Freedom Forever
Planset Revision Letter

11/26/2024
REV #2

RAYMOND PATTERSON
118 OLEANDER LANE

ROOF MOUNT PHOTOVOLTAIC SYSTEM

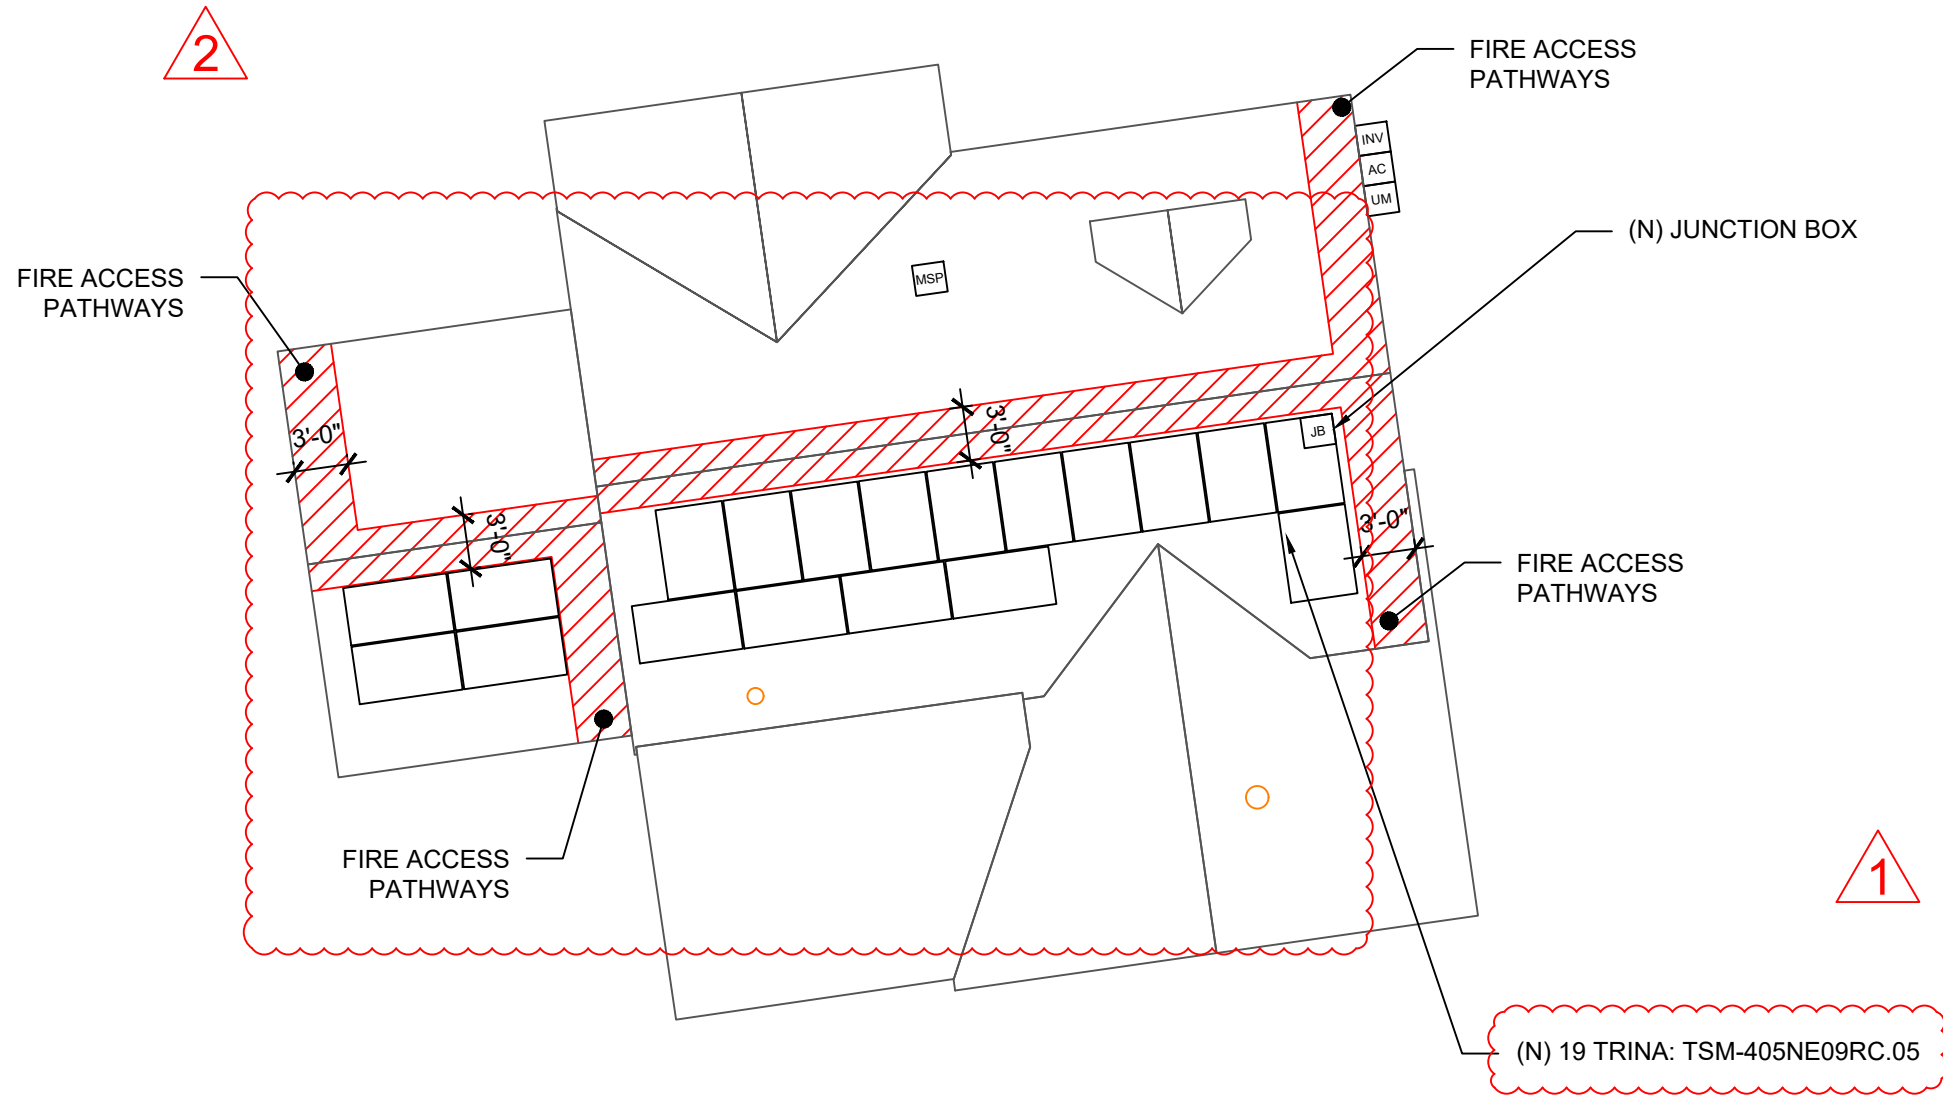
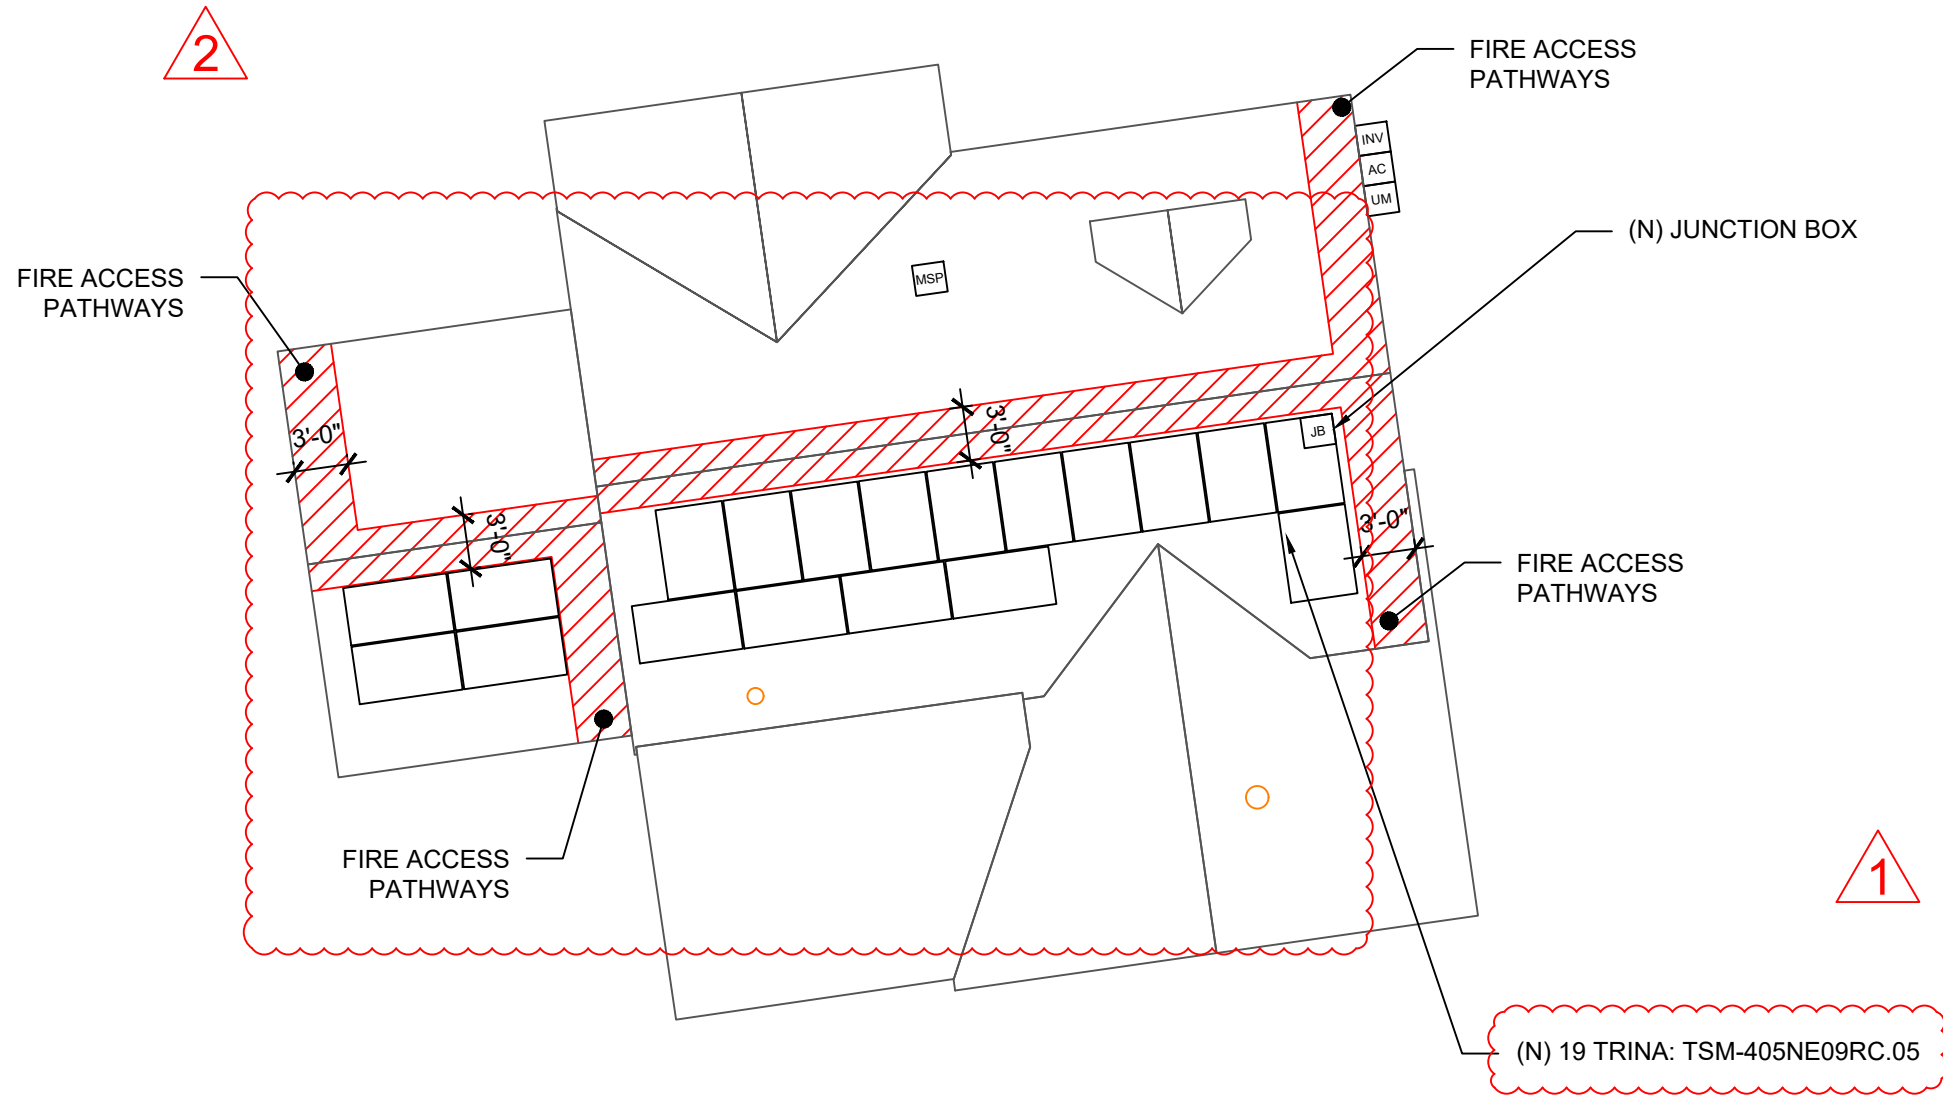
MODULE SWAP SILFAB 430 TO (19) Trina: TSM-410NE09RC.05 AS PER INSTALL

Layout changed as requested.
